Charlotte Department of Transportation

Memorandum

Subject: Rezoning Petition 08-078: Located on the north side of East Mallard Creek Church Road between Stone Quarry Road and Bonnie Cone Lane (revised 4/18/08)

**REZONING
SITE PLAN
REZONING PETITION
2008-078**

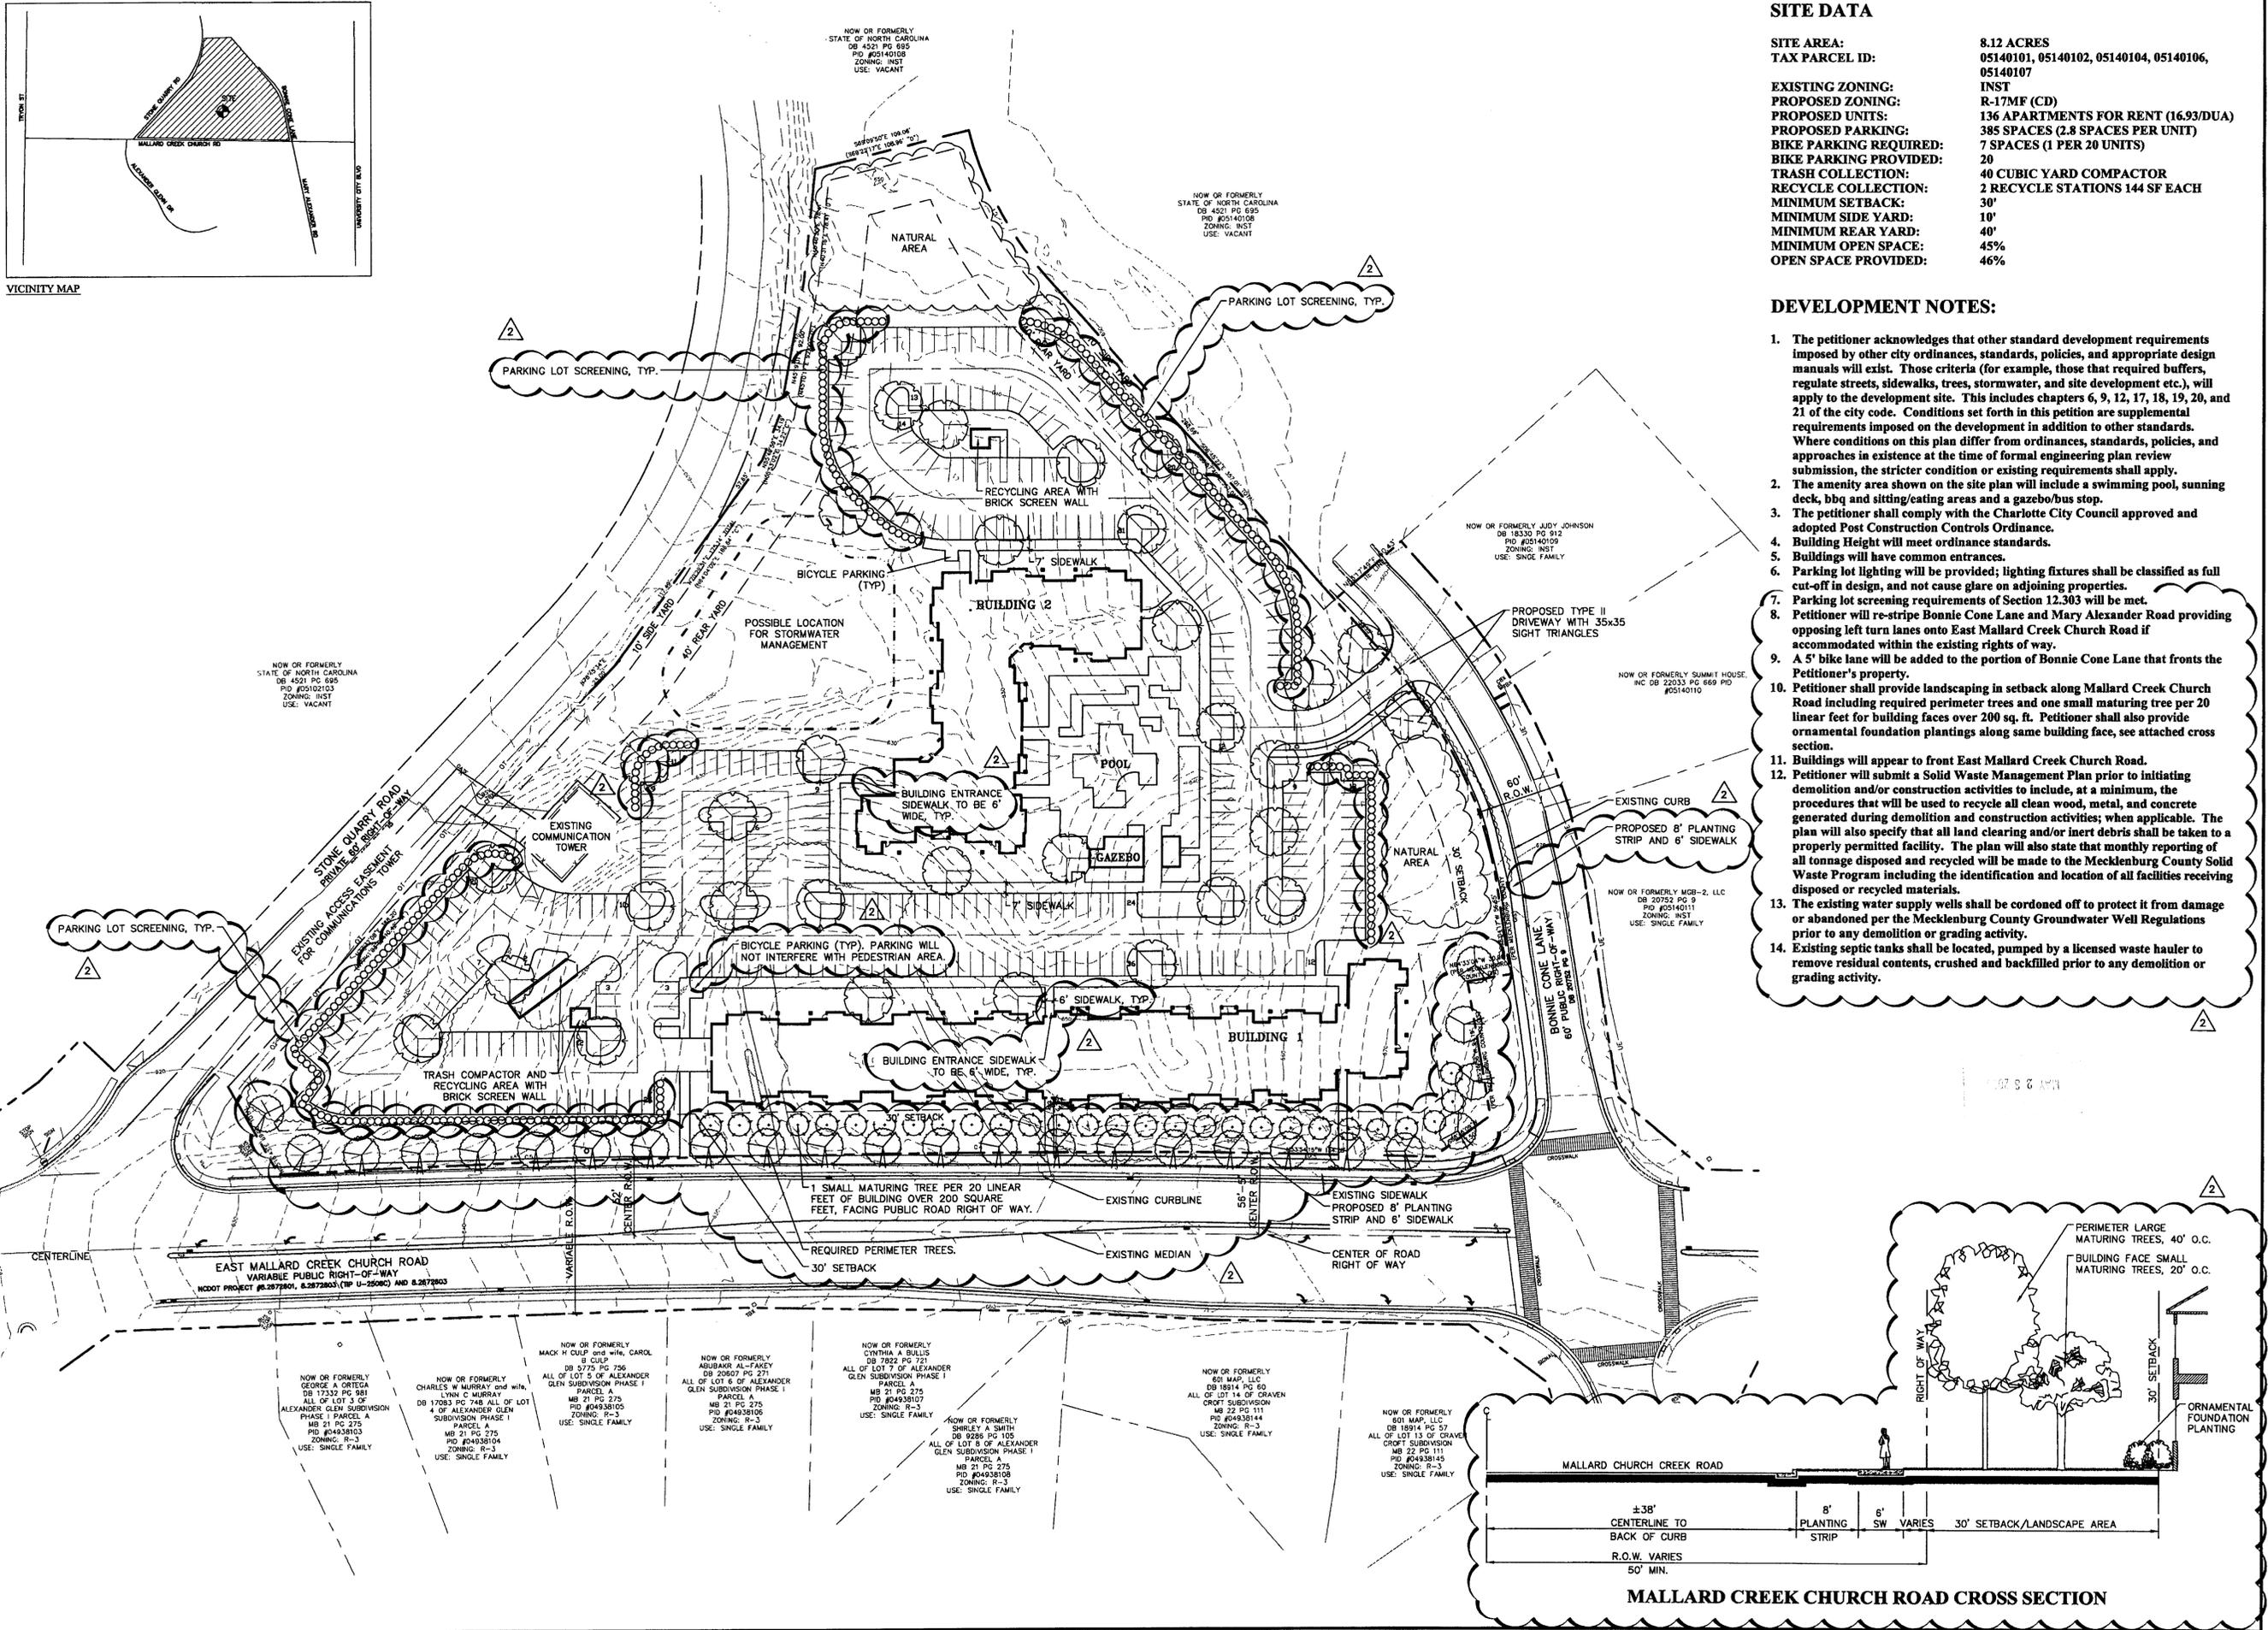
1. An 8-foot planting strip and 6-foot sidewalk needs to be provided along the public right-of-way for Bonnie Cone Lane, as measured from the new curb line. (*Previous Review Comment-2*)
